## BULLETIN No. 2

Date: December 27, 2012

RE: **TSL Building - Showroom and Service Bay Additions  
Portland, Maine**

JHN #: 2008-279.3

1
A101
FLOOR PLAN
SCALE: 1/8" = 1'-0"

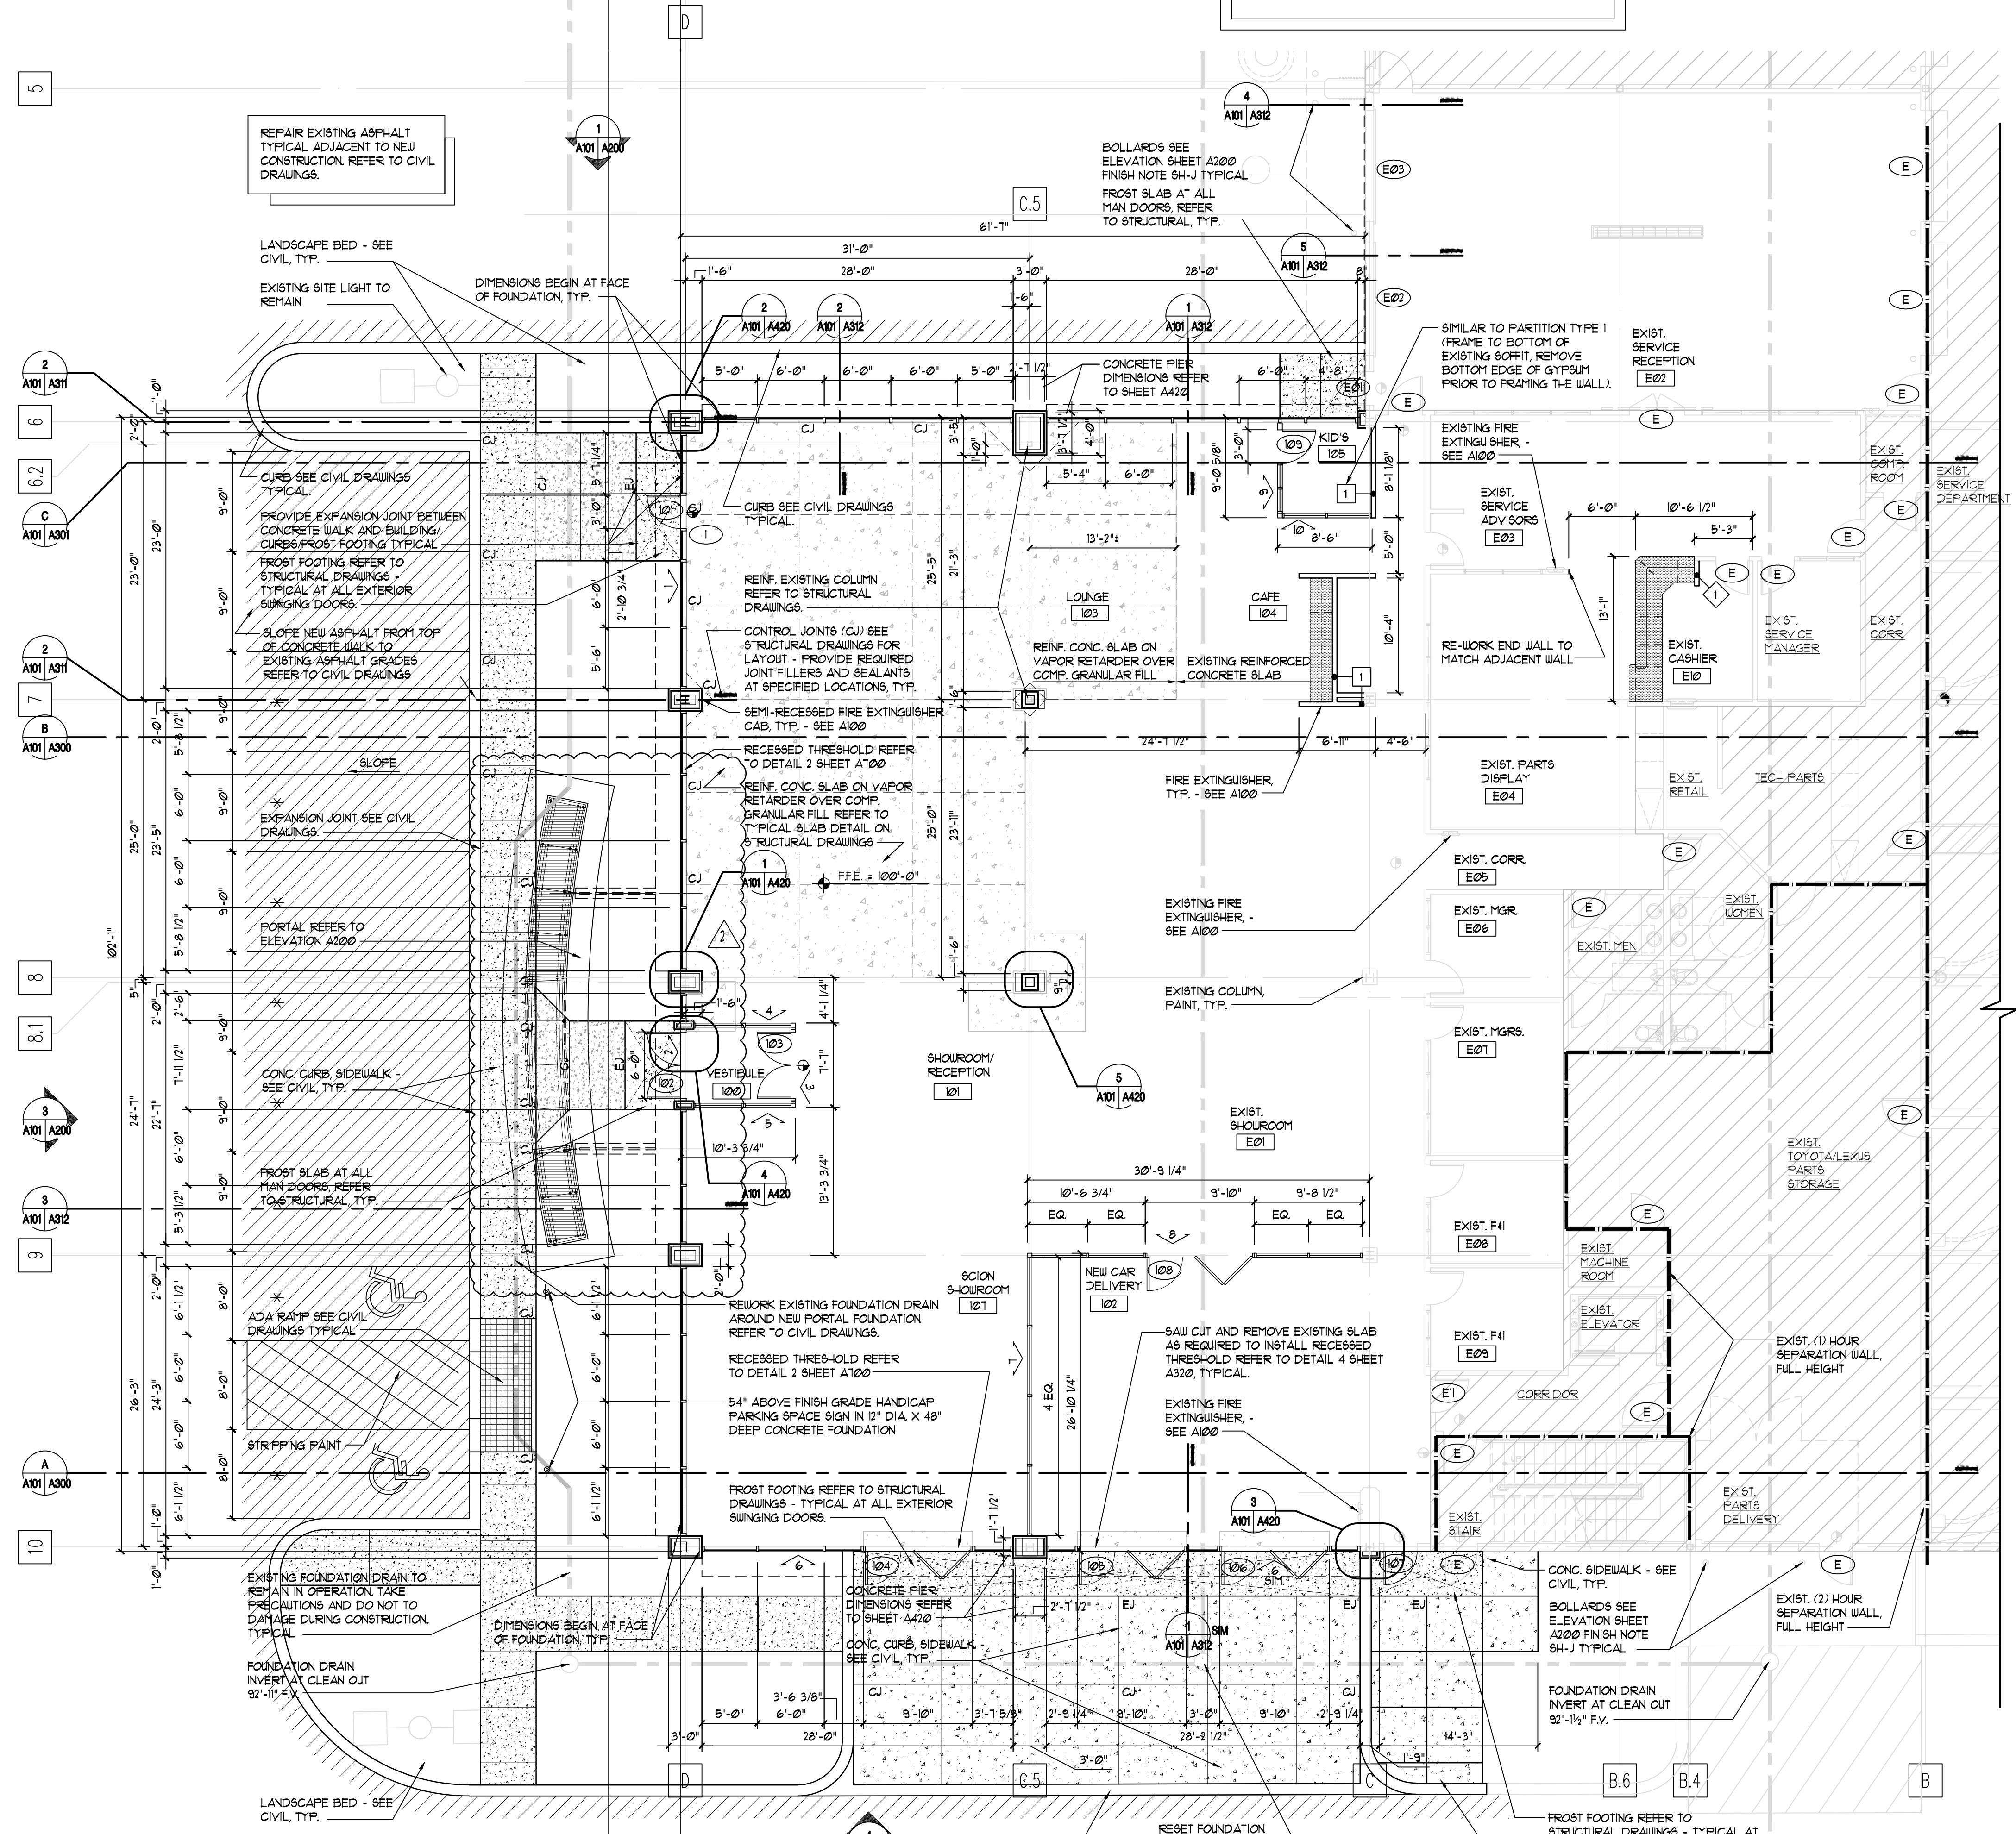
Item 2.1 Refer to Sheets A101, A200, A310, A320

- *Shifted portal out 4'-0" do to existing conditions.*
